Subject: FW: H14-0083-26 Kendall Grove, Pinchbeck

Subject: RE: H14-0083-26 Kendall Grove, Pinchbeck

Drawing 4.1 – Mitigation drawing

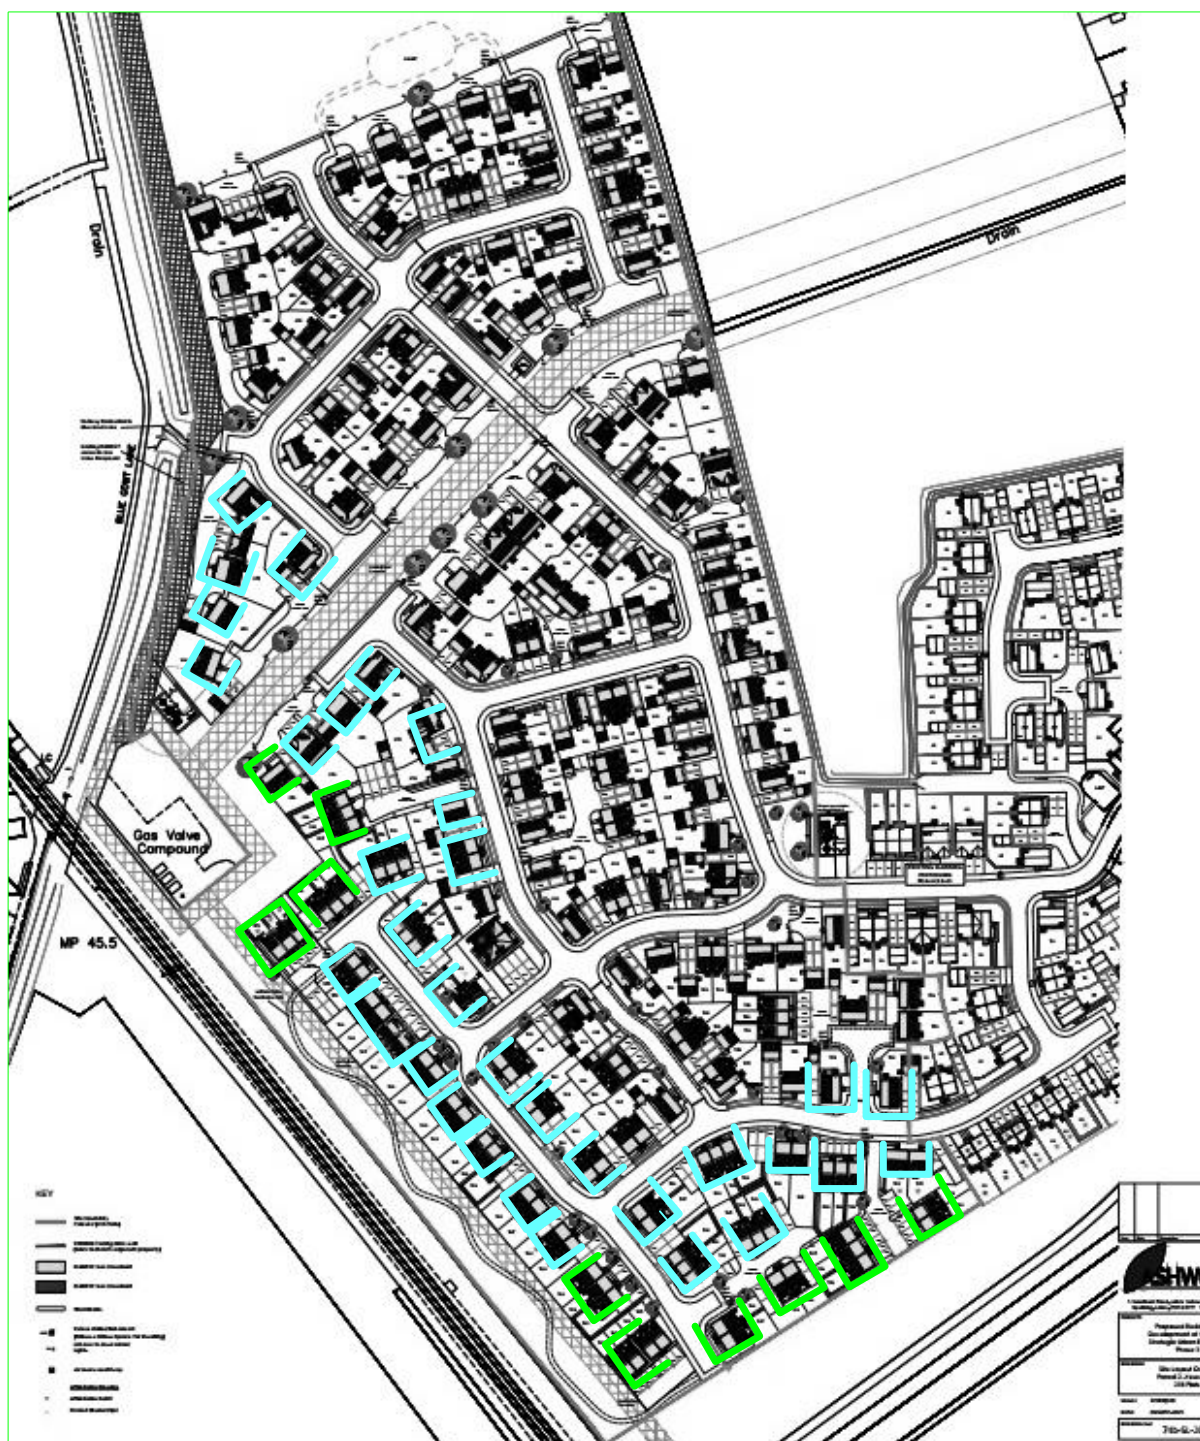
We note the updated acoustic glazing requirement to plots 123-148, 172-177, 207-209 & 215 as shown on revised Acoustic Measures Plan drawing 74b-AMP-211/A, and we confirm the revised cost as £84,600.

LEAP (4.14 & 4.15)

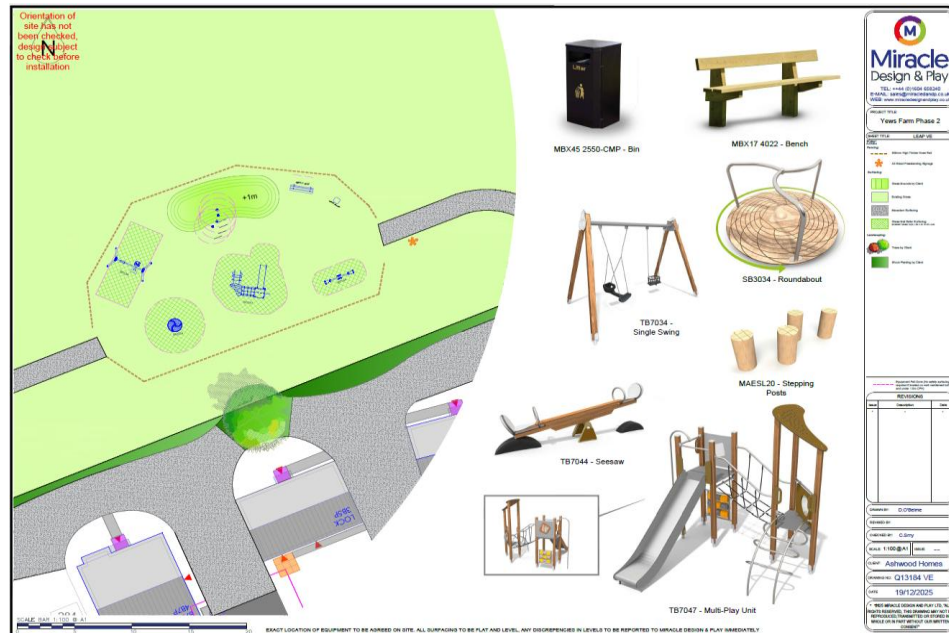
We stand by our comments that we do not consider these two items to be abnormals, and that the costs should be transferred across to the normal construction cost section.
